APPLICATION NO. <u>06DRB00110</u>	PROJECT NO. <u>1004665</u>
PROJECT NAME <u>SANDIA SCIENCE &amp; TECHNOLOGY PARK</u>	
APPLICANT / AGENT <u>DCSW</u>	PHONE NO. <u>843.9639</u>
ZONE ATLAS PAGE <u>M. 21</u>	DATE SUBMITTED <u>1-26-06</u>

February 9, 2006

RE: COMMENTS ON SANDIA NATIONAL LABS OFFICE BUILDING  
SANDIA SCIENCE & TECHNOLOGY PARK

SHEET TITLE
OVERALL SITE PLAN

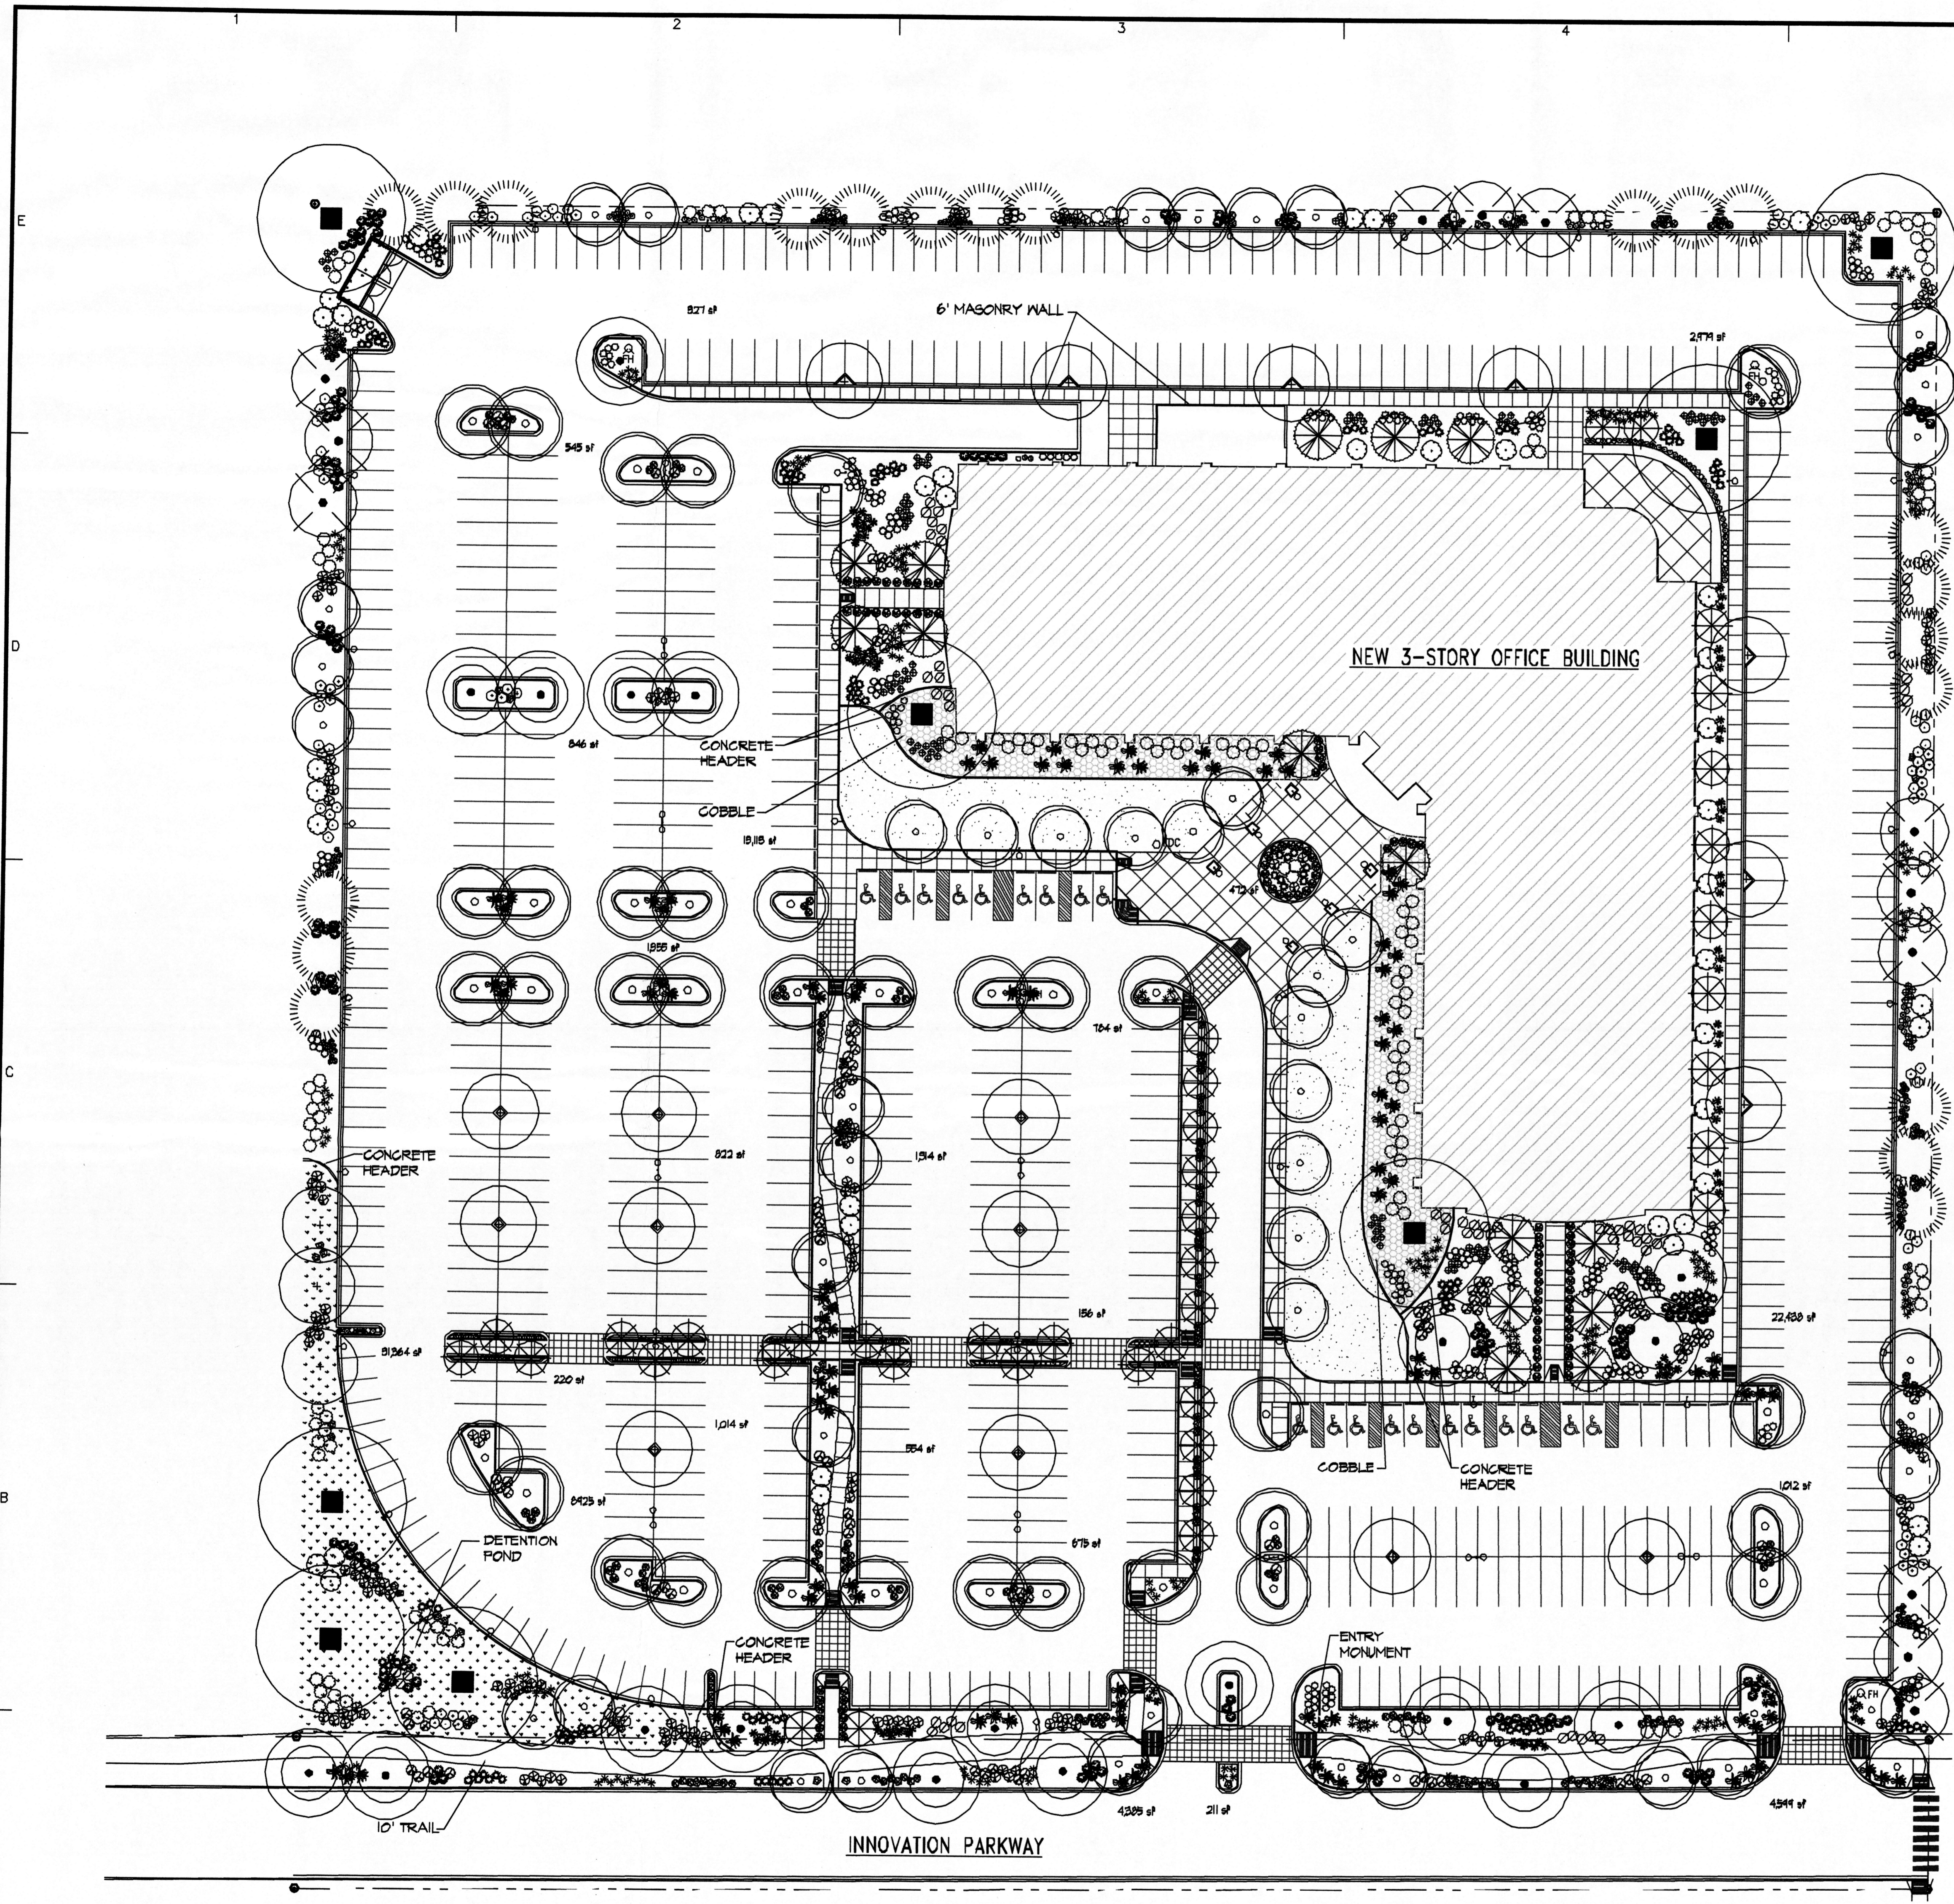
1. The SS&TP Architectural Control Committee must sign off on the site plan sheet before Planning signs. The appropriate time to get their signature in this case is after you make Planning's corrections. Each of the site plans Planning has reviewed before this one have also been signed by the ACC before signed. In addition, I will need an acceptance letter from the ACC.
2. This site plan does not meet the 25' parking setback along Innovation Parkway, as required by the Design Standard on page 39 of the SS&TP Master Plan. The site plan appears to have only about a 12' setback.

The intent of the Master Plan is that the parking setback be measured from the northern boundary of the right of way easement. Because the roadway sets on an easement throughout the Park, it is apparent that this is the intention.

Also, the language on Page 39 referring to an exception to the 25' setback requirement was meant as a "grandfathering" in of an already approved site plan for the EMCORE development, Phase 2. The EPC had approved the EMCORE plan in 2000, before the 2001 approval date of the SS&TP Master Plan. Because this current proposed development is not part of EMCORE but a Sandia National Labs Office Center, the exception does not apply.

If you as the agent and the applicant can work out a compromise with the SS&TP Architectural Control Committee, the City will accept their approval of an exception to the 25' parking setback.

clearly where the site is located. It should be placed on the site plan sheet. (Also required on the SPBP Checklist)

L-101

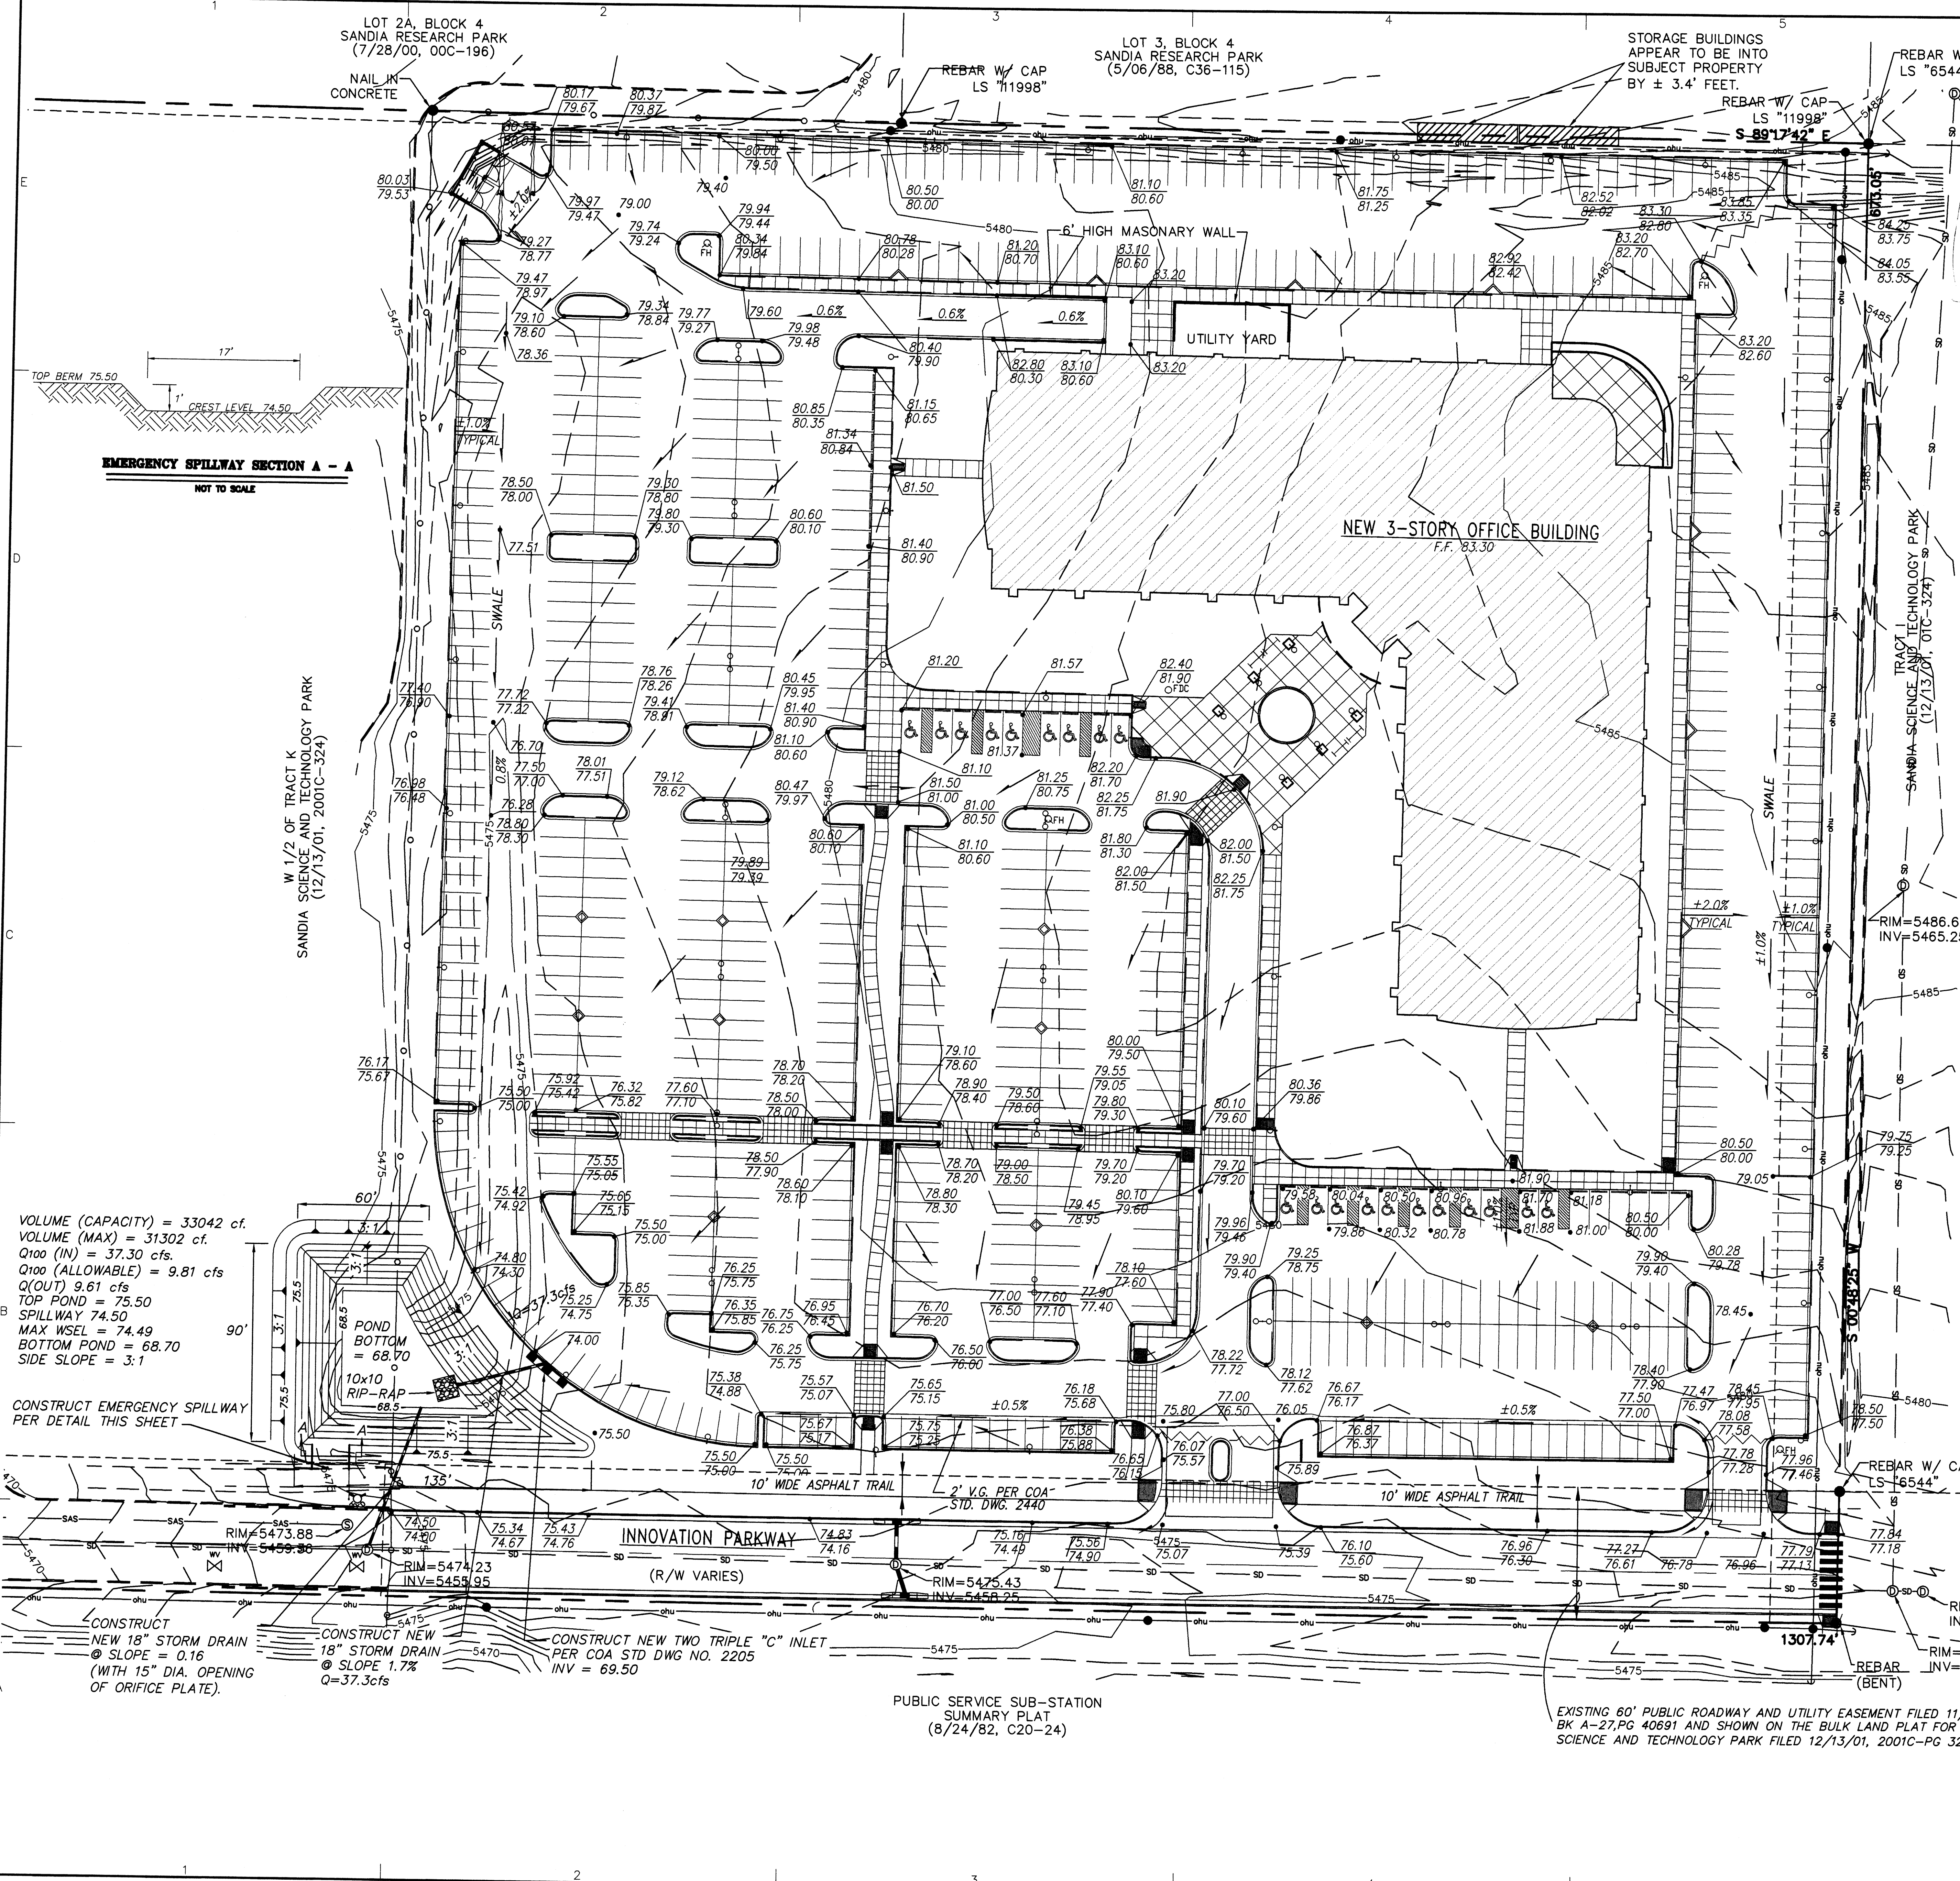
5. The Journal Center is working with the City to decrease the amount of high water use plants they are including in new development. SS & TP should avoid the use of high water use plants as well. Please re-look at the landscaping plan to see where water use can be further reduced.
6. Solid Waste should sign off on the site plan sheet. Please have them do so.
7. The total width of the building is missing as a dimension on the building Elevations sheet.
8. The sign colors are missing from the elevation.
